The Member-Secretary,  
Madras Metropolitan  
Development Authority,  
Thalamuthu Natarajan Bldg.,  
Gandhi Irwin Road,  
Egmore, Madras-600 008

Letter No: A1/21479/92

Sub: MMDA - Planning permission - Construction of residential building at S.No:133/1, of Paruthipattu village - approved - Reg.

SITE PLAN

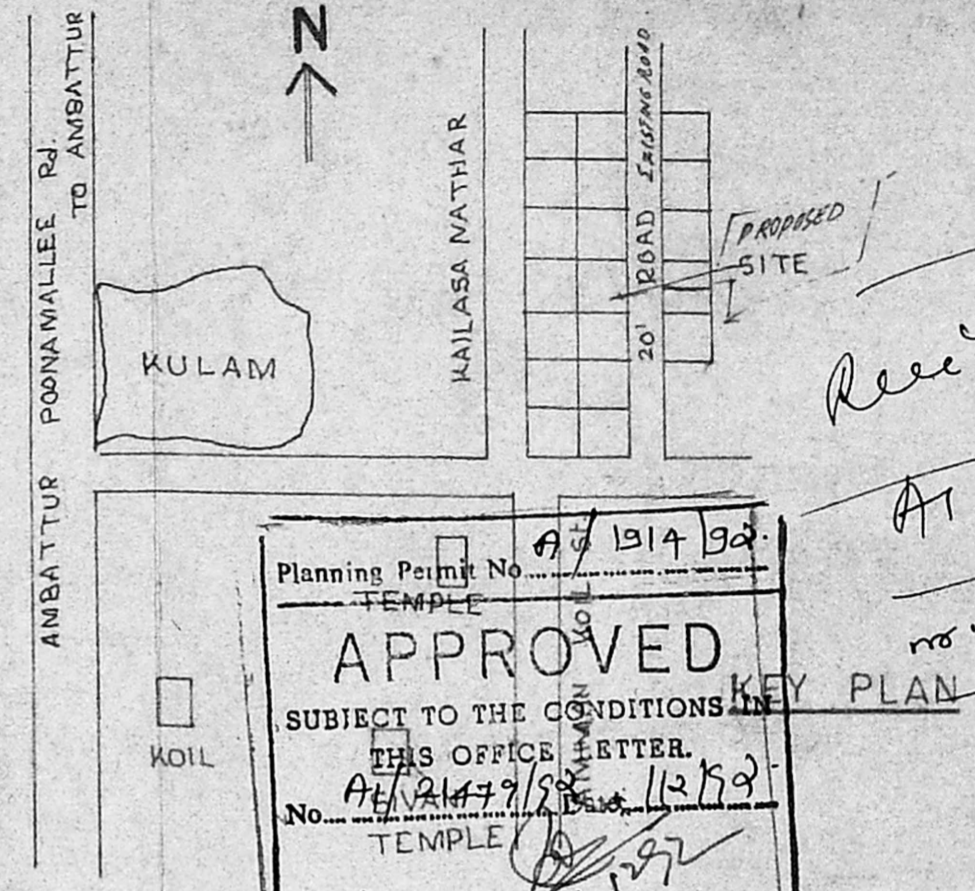
You are also requested to furnish the revised plan satisfying the site set back to DCA to furnish a specific undertaking. On receipt of the amount, the approved plans will be sent to Executive Officer, Avadi township for further action.
